Our Ref: P8104/PB
Date: 5 March 2024

**Planning Permission 22/01632/REM
Non-Material Amendment to Application
Unit 6 - Land to the East of Wendlebury Road, Bicester**

2310-BA-15-E1-DP-A-0200 Proposed Elevations

Drawing Title  
Revision Number  
2310-BA-15-E1-DP-A-0200

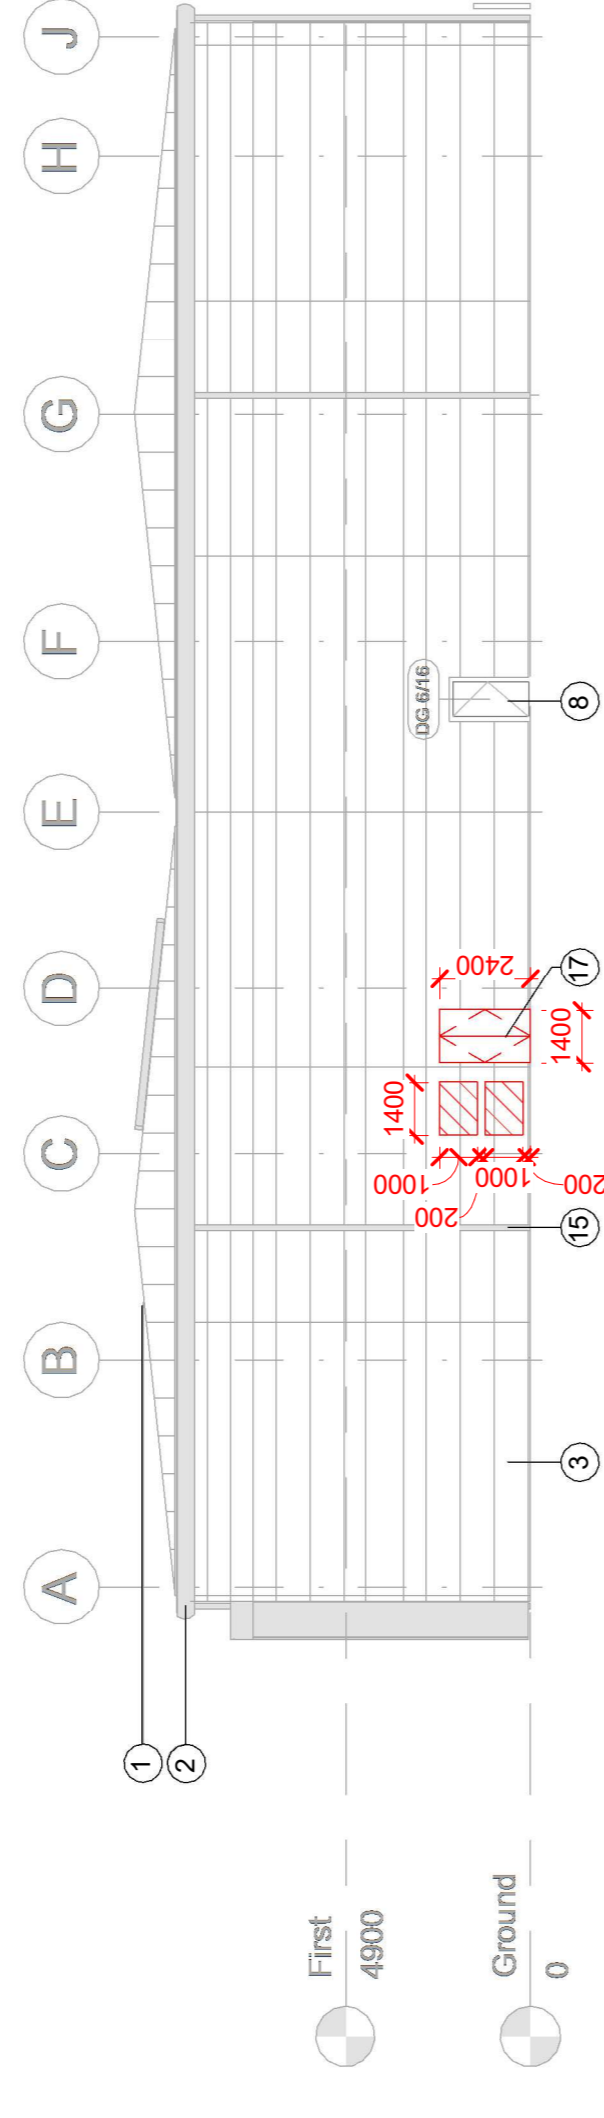
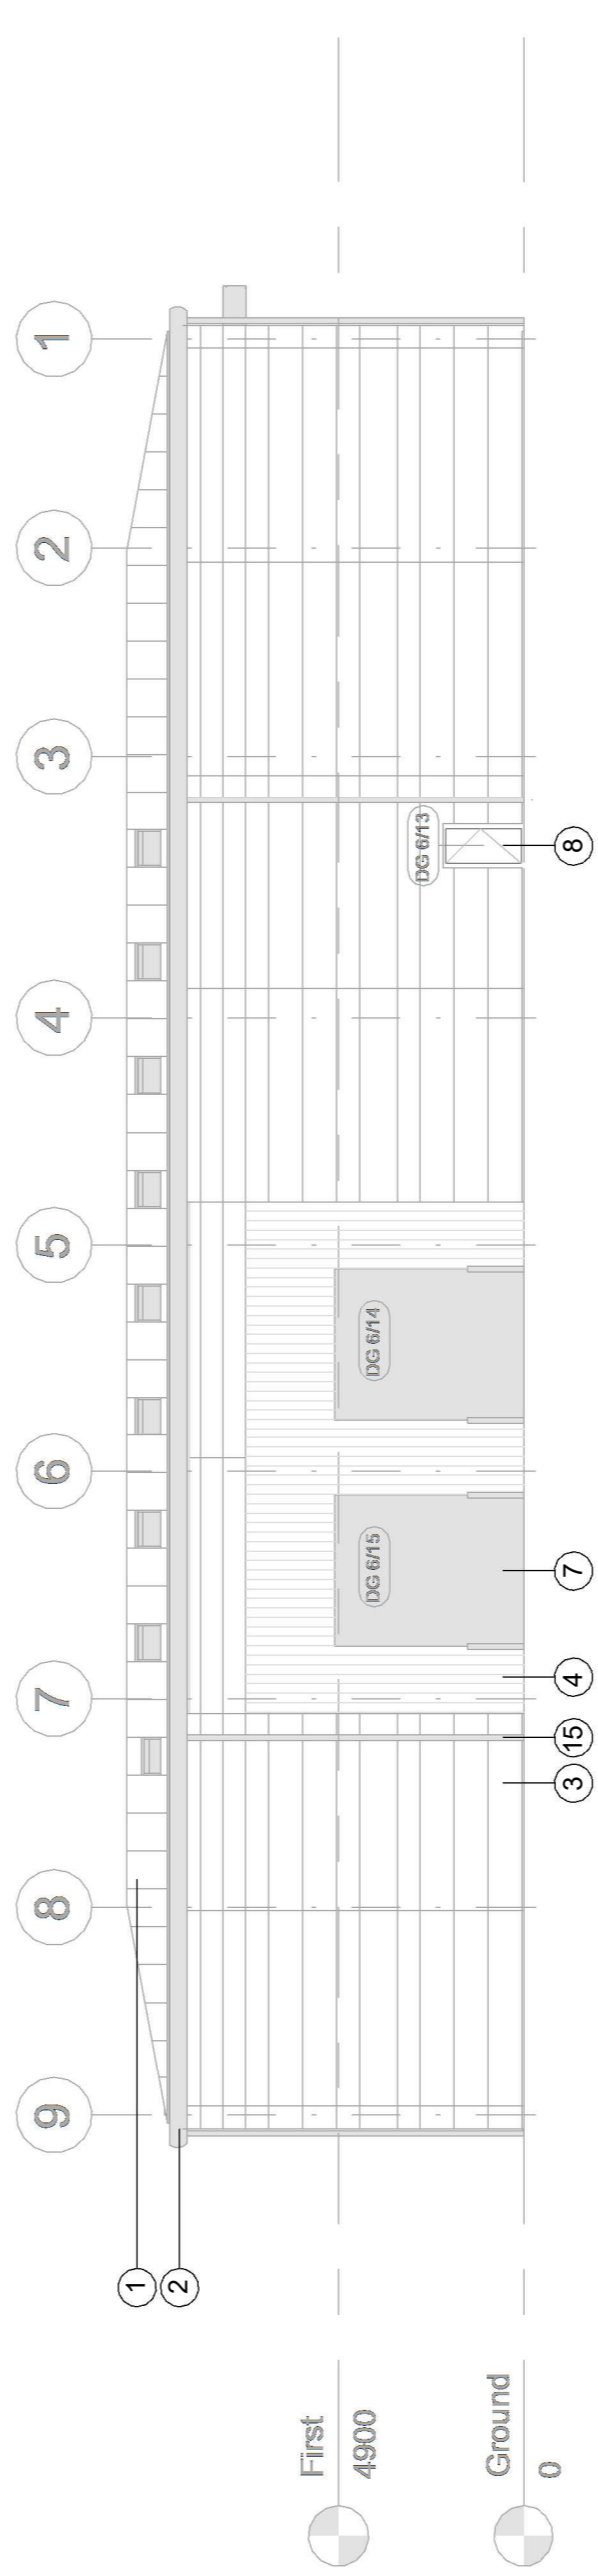
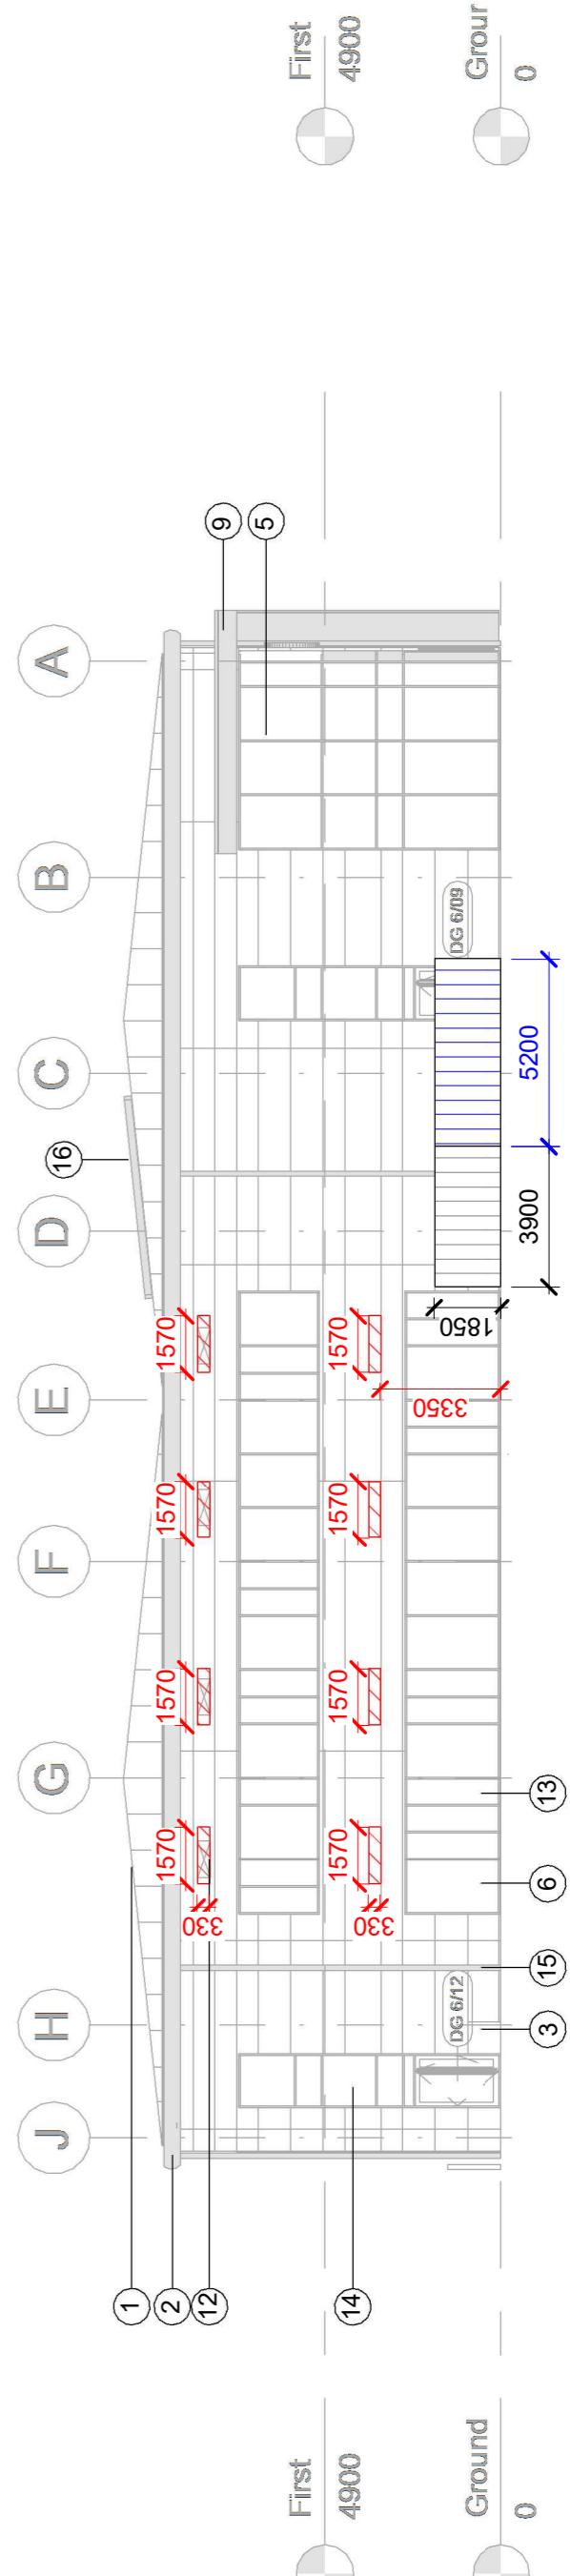
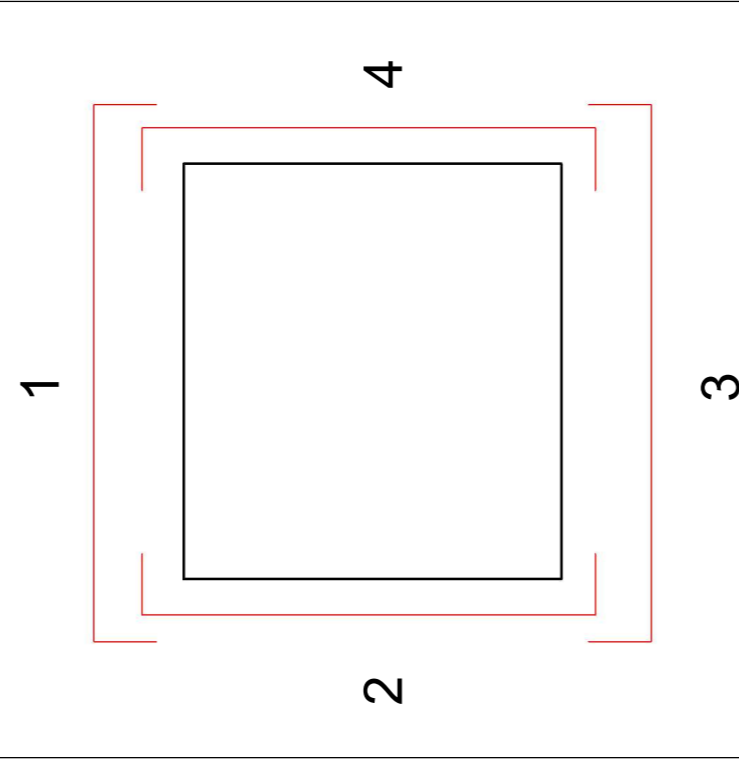
The following amendments are proposed and are considered to represent non-material amendments to planning permission 22/01632/REM. The extent of the proposed changes are marked red on the proposed elevations for ease of reference:

1. Louvers
2. Metal double doors, colour and finish to match adjacent
3. Extension of external plant area, finish and materials to match existing
4. Two new windows.
